**KIRKLEES METROPOLITAN COUNCIL
INVESTMENT & REGENERATION SERVICE**

**DELEGATED DECISION TO DETERMINE APPLICATIONS FOR
CONSENT, AGREEMENT OR APPROVAL REQUIRED BY CONDITION**

Reference No:	2024/44/91602/E
Site Address:	156, Upper Road, Batley, WF17 7BJ
Description:	Discharge conditions 1-20 on previous permission 2022/91343 for conversion of public house to form two dwellings, erection of garages and one detached dwelling, demolition of external outbuildings and associated works
Recommending Officer:	Nina Sayers

DECISION – Discharge of Conditions 5, 8 and 12 - Approved

drawing no	rev	date	
DWG-0121	-	MAY-2024	
scale	drawn	checked by	checked date
1:150@A1	SMT	ST/AJW	MAY-2024

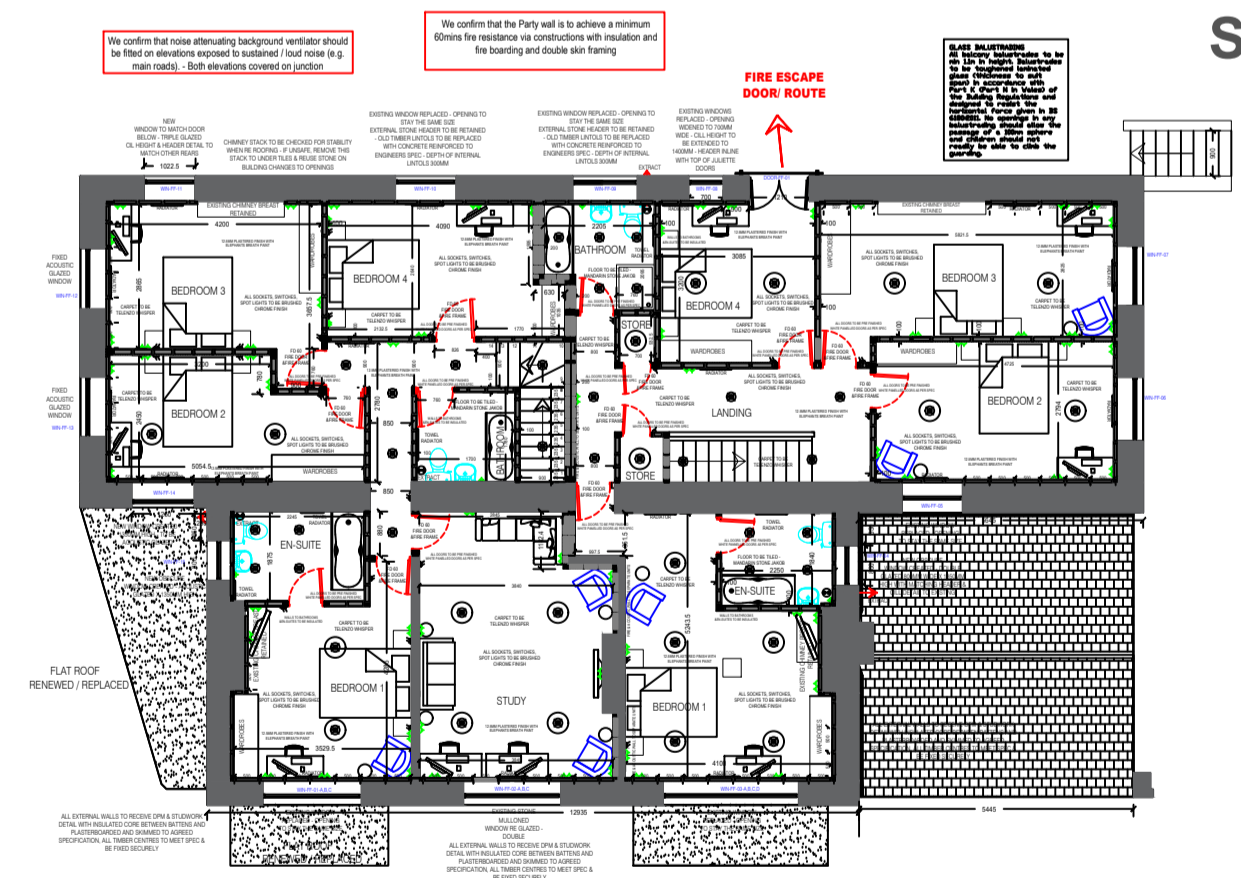
The applicant has outlined within their planning statement that the fencing and boundary treatments shall be 1.8m high timber fencing, vertical slatted with concrete fixed posts at 2m intervals and secured with horizontal fixings top, mid and base. There is no detail provided of where this fencing will be located and therefore officer require a site plan detailing the location of the proposed boundary treatment before they can discharge condition 5.

No details of the routing of the construction traffic to and from the site, or details of the times of use of the access, have been provided. KC Highways

Development Management have been consulted and have commented that routing should be via the A638 Halifax Road from the south, all other turning movements into the site will be extremely difficult for larger vehicles. Timing should avoid the peak AM and PM hours for traffic 8.00 to 9.30 and 16.00 to 18.00.

Details of where bins are to be stored and the location of bin presentation points are provided on the Proposed Site Plan ref: DWG-0121 and DWG-0122. The planning statement outlines that *“the bins for the collection date will be brought to the kerbside location the day of the collection in line with the rest of the Streetscene for residential collection of household, recycling and garden waste. They will then be returned to the locations marked on the plans attached for each of the dwellings.”* KC Highways Development Management and KC Waste Strategy have been consulted on the proposal and have no objection to the discharge of condition 9.

The applicant has submitted a Proposed Site Plan (drawing no. DWG-0121) and a planning statement in order to discharge condition 15. These documents confirm that a Standard Electric Vehicle Charging point (of a minimum output of 16A/3.5kW) will be installed at each residential unit that has a dedicated parking space.

Proposed Ground Floor Plan on Site Plan Showing conditional discharge detailing

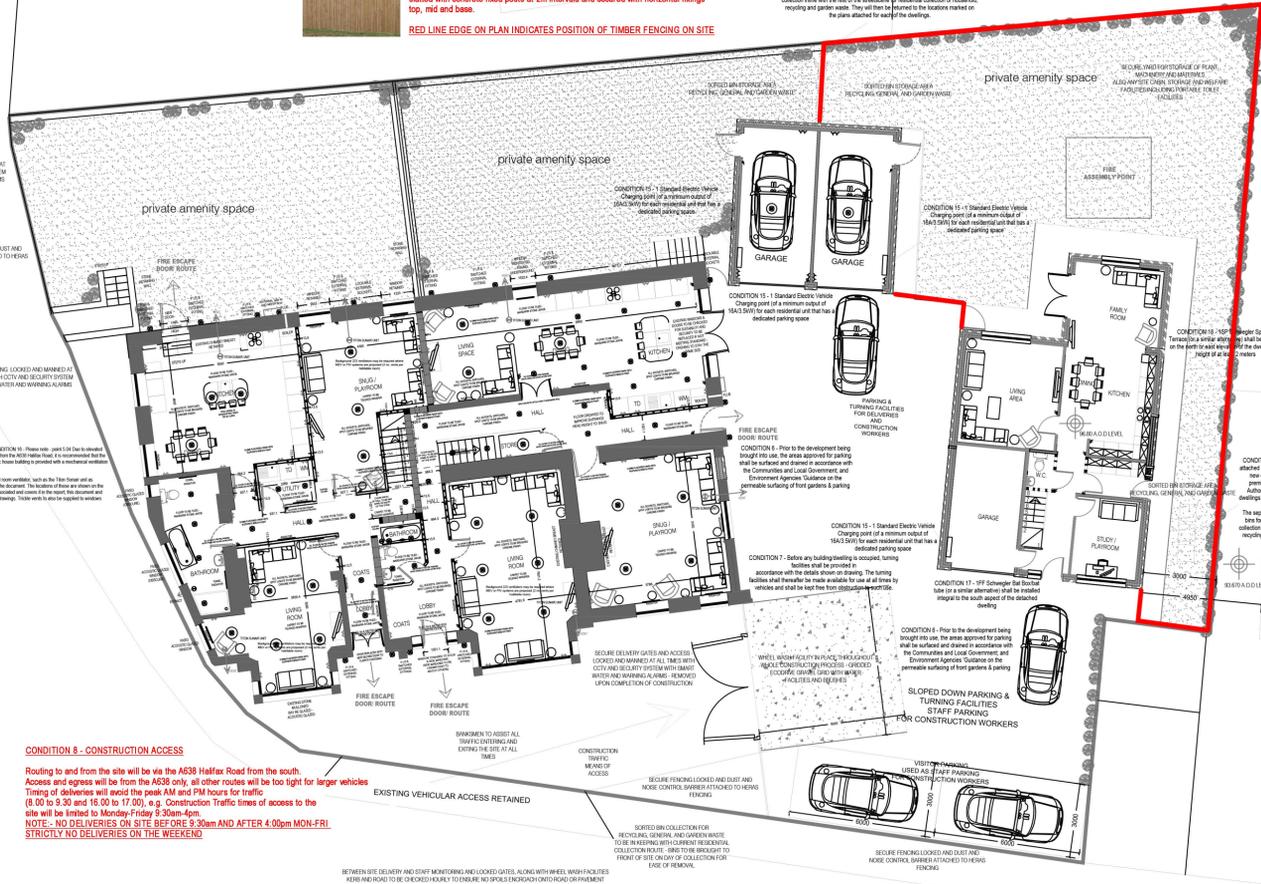
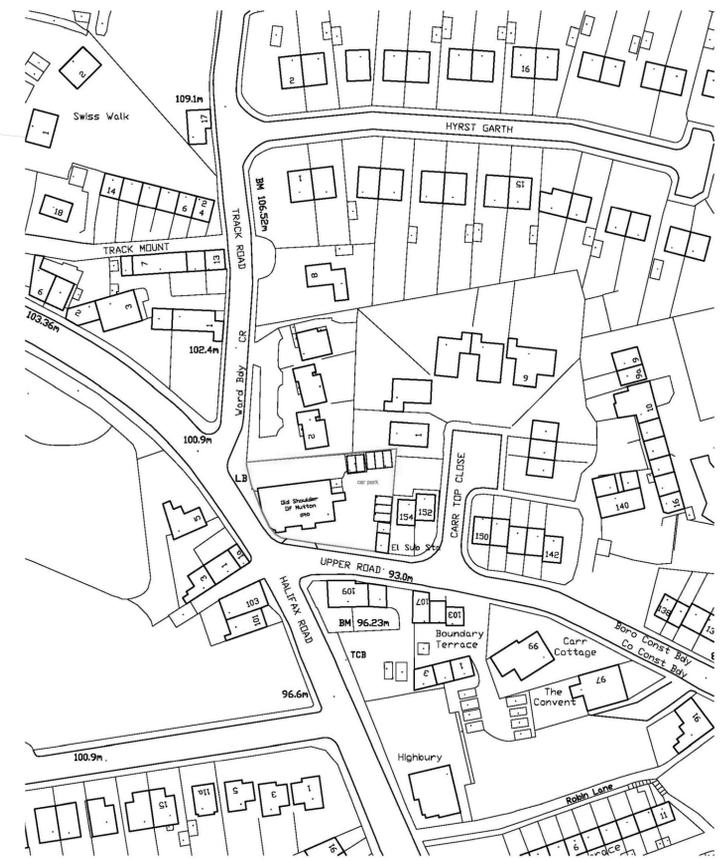
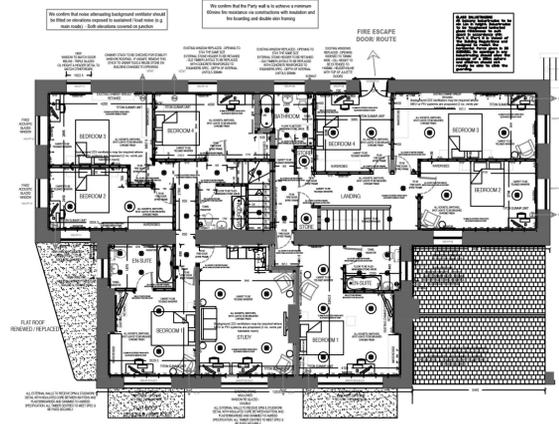
Following the previous decision notice (dated 12-AUG-2024), the applicant has submitted drawing no. "DWG-0121 Rev.B" which includes a detailed annotation regarding construction access and demonstrates the location of the proposed fencing. The relevant conditions have been re-assessed below:

The submitted drawing no. "DWG-0121 Rev.B" outlines the location of the proposed fencing along the boundary of the detached dwelling which is considered acceptable and appropriate for the purposes of discharging condition 5

The submitted drawing no. "DWG-0121 Rev.B" demonstrates the following:

- Point of access for construction vehicles would be to the south of the site and would be routed off A638 Halifax Road
- Construction traffic times of access would be limited to Monday-Friday 9:30am-4pm to avoid peak hours of traffic.
- Parking provision would be provided for two vehicles to the south-eastern corner of the site.
- Wheel wash facilities would be in place throughout the whole construction process and would be adjacent to the access.

The submitted details within the annotations on submitted drawing no. "DWG-0121 Rev.B" are considered sufficient for the purposes of discharging condition 8 and KC Highways Development Management have no objection to the submitted information.

Condition 5 can therefore be discharged. The development shall thereafter be completed in accordance with the approved details before the dwellings are first brought into use and thereafter retained.

Condition 8 can therefore be discharged. Unless otherwise agreed in writing by the Local Planning Authority, all construction arrangements shall be carried out in accordance with the approved schedule throughout the period of construction.
